2nd Floor, FC1: C22' (i2655) - 2 such damaged joists

FORTEWEB Software Operator	Job Notes
Raj Honnavara P.E. (TX, CO, OK, LA, NM) Weyerhaeuser (972) 478-6831 raj.honnavaara@weyerhaeuser.com	Lot 23 Duncan Crossing, Smith Douglas Homes - McGinnis Model TC #142168

2nd Floor, FC1: Repaired C22' (i2655) - 3 such damaged joists
1 piece(s) 14" TJI® 110 @ 24" OC

2ND FLOOR LAYOUT

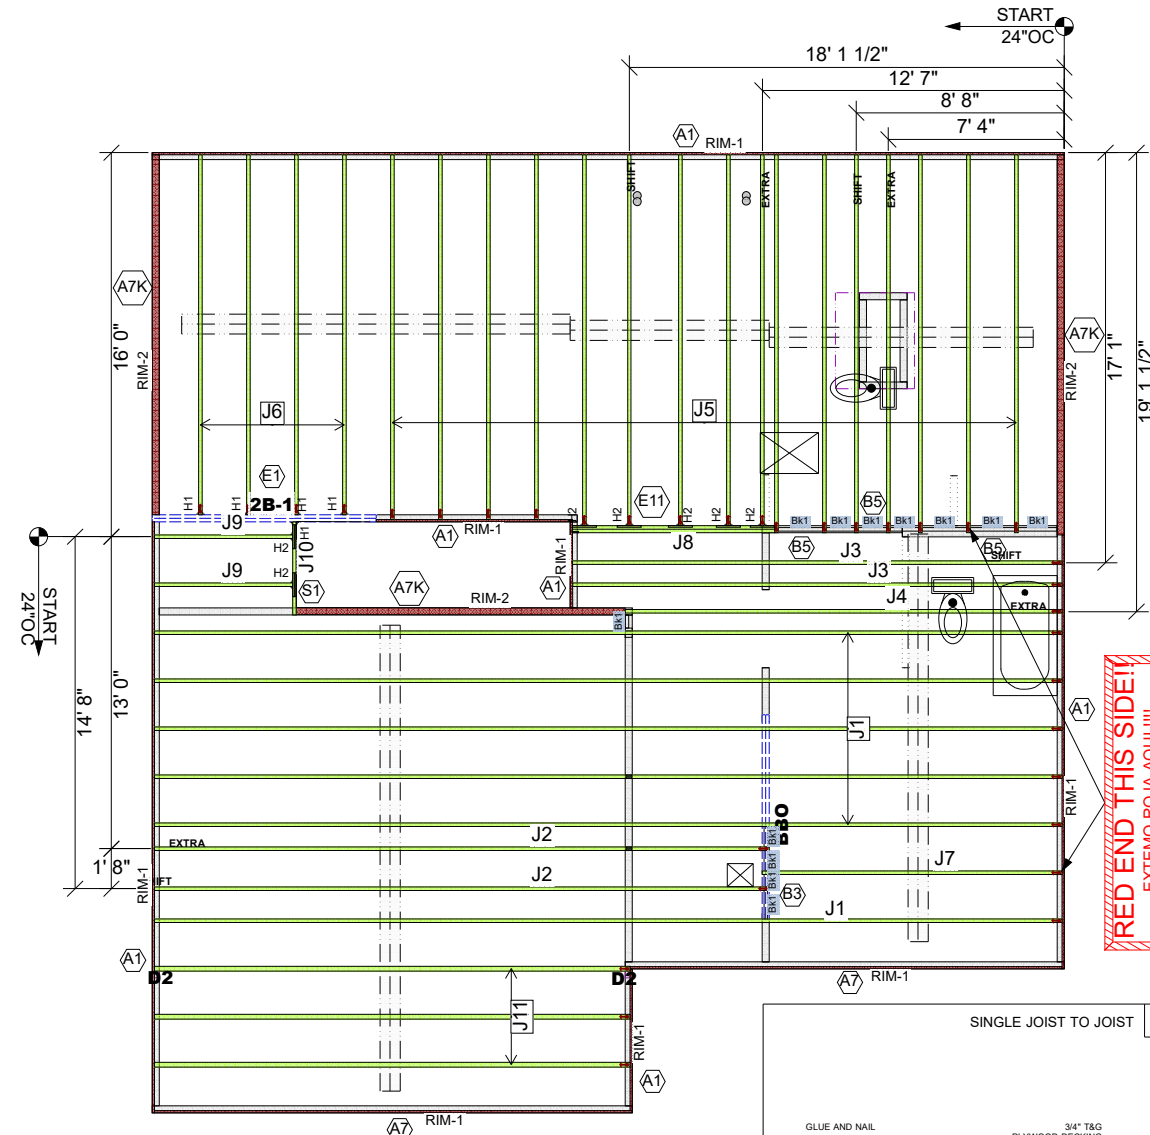
Holes (Size)	Width	Height	Vertical Offset	Location	Shear (lbs)			Comments
					Actual	Allowed	Result	
1 - Slotted (M)	7.00"	6.00"	9 1/2"	6' 2"	210	-	Fails	Hole too close to bearing, repair per notes

This joist is Structurally Inadequate with the hole being too close to support 2 as shown above. To remedy this situation, notch the top plate at support 2, by 1 1/2", so that the joist is not supported at that point, be cautious not to damage the bottom flange of the joist. This will eliminate one of the supports, and the joist will clear span about 12' in that area. See calculation shown on pages 3 & 4 that reflects this condition.

Holes (Size)	Width	Height	Vertical Offset	Location	Shear (lbs)			Comments
					Actual	Allowed	Result	
1 - Slotted (M)	7.00"	6.00"	9 1/2"	6' 2"	210	673	Passed (31%)

Location Analysis	Shear (lbs)			Moment (Ft-lbs)			Deflection (in)		Comments
	Actual	Allowed	LDF	Actual	Allowed	LDF	Live Load	Total	
1 - 6' 2"	-73	1860	1.00	657	3740	1.00	0.034	0.045	1 3/4" wide x 4" long x 1/4" deep (max) bottom flange notch at hole- Passes as is
